Application No: LU/258/15/HH

Recommendation Report for Planning Permission for Works or Extension to a Dwelling

LOCATION: 6 Willowbrook
Littlehampton

PROPOSAL: Retention of fence in back garden and change of use from highway verge to C3 Residential use.

PHOTOS OF GARDEN
BEFORE FENCE

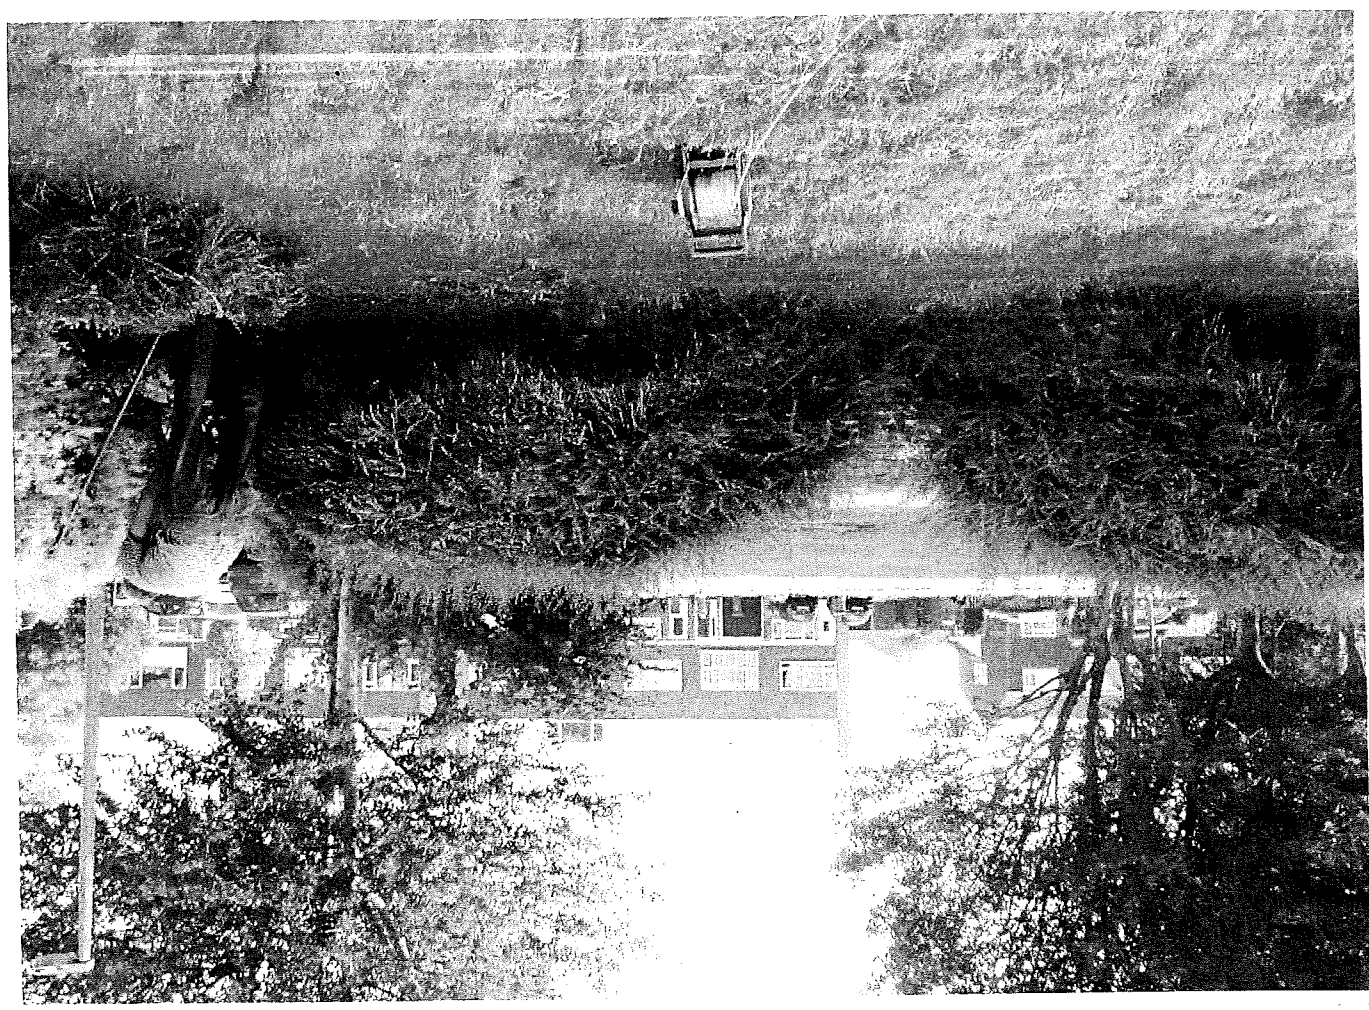
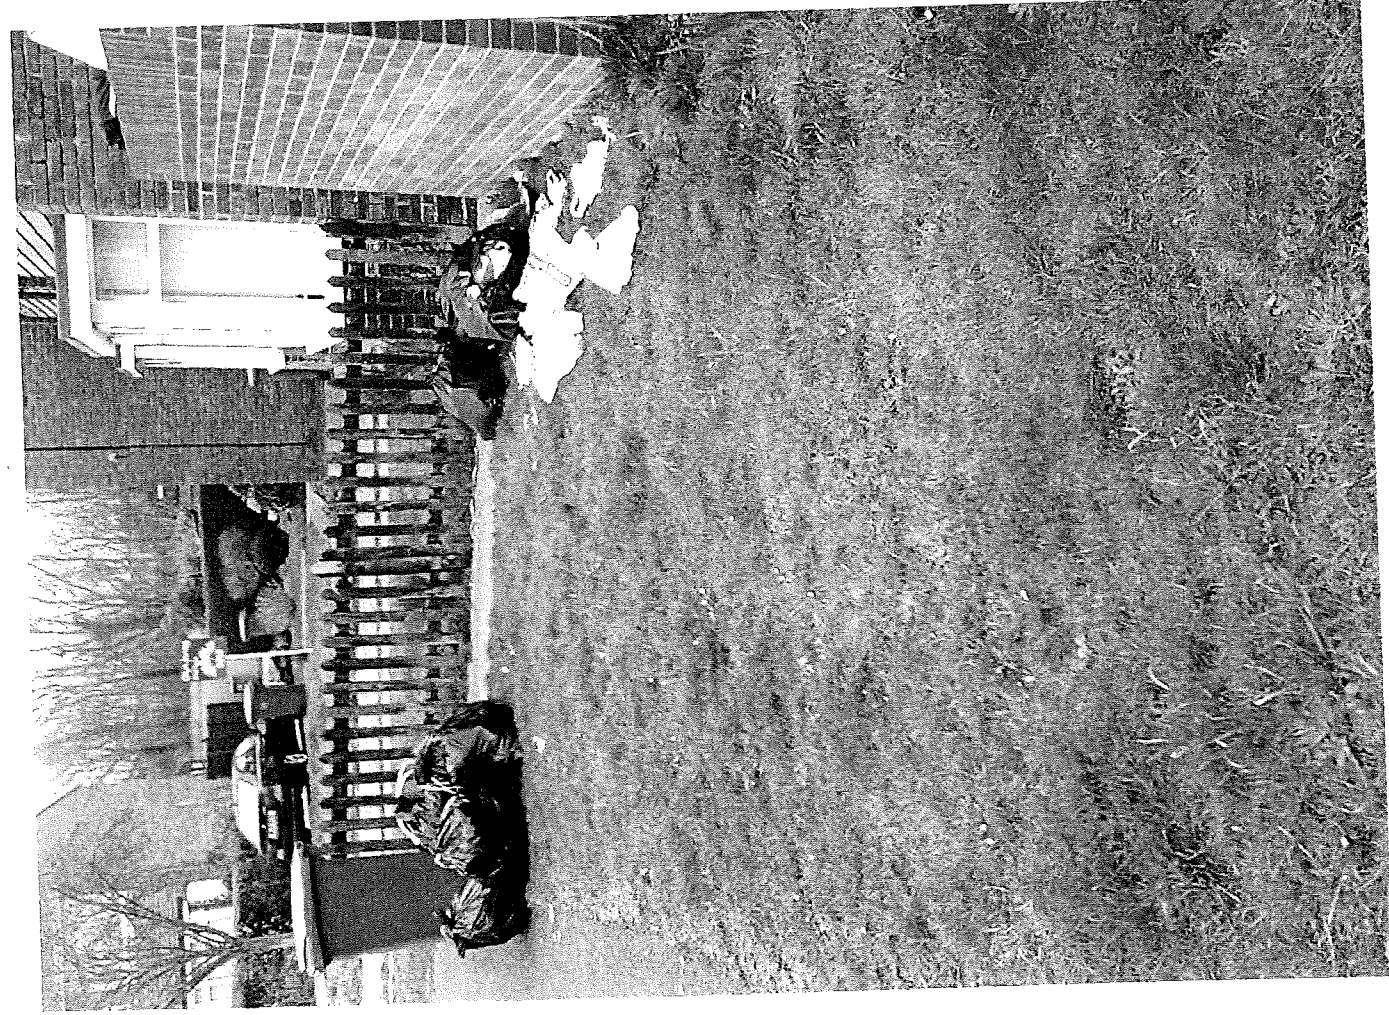
The rear garden of the applicant's property has been extended beyond the building line (i.e. in front of the houses at 8 - 18 Willow Brook), impacting on views southwards and approaching Willow Brook.

character of the area. The newly installed fence and change of use of land to private garden space do not 'respond positively' to this characteristic which is considered to be significantly harmed by the enclosure and the prominence of the fence in the streetscene.

The character of the estate remains open plan generally to this day. It is considered that the fence as constructed and the change of use of land is in conflict with policy above because it encloses open land, narrows views into and out of the estate and removes green verges. It is therefore considered that the fence and change of use has an unacceptable impact on the character and appearance of the area.

The Council operates the 45 degree rule to assess the impact of development on the amenity of neighbouring residents by way of overshadowing and loss of light. In this case the fence as constructed marginally intersects the 45 degree line measured from the centre of the living room window at 8 Willow Brook, the neighbouring property. The fence is therefore considered to have an overshadowing impact on the habitable room windows of 8 Willow Brook and thereby serve to have a loss of daylight and sunlight to that property.

The proposed fence is therefore considered contrary to GEN7 (iv) of the Arun District Local Plan and policy D DM4 (c) of the Emerging Arun District Local Plan as it has an unacceptable impact on neighbouring amenity through a loss of daylight and sunlight to the neighbouring property.
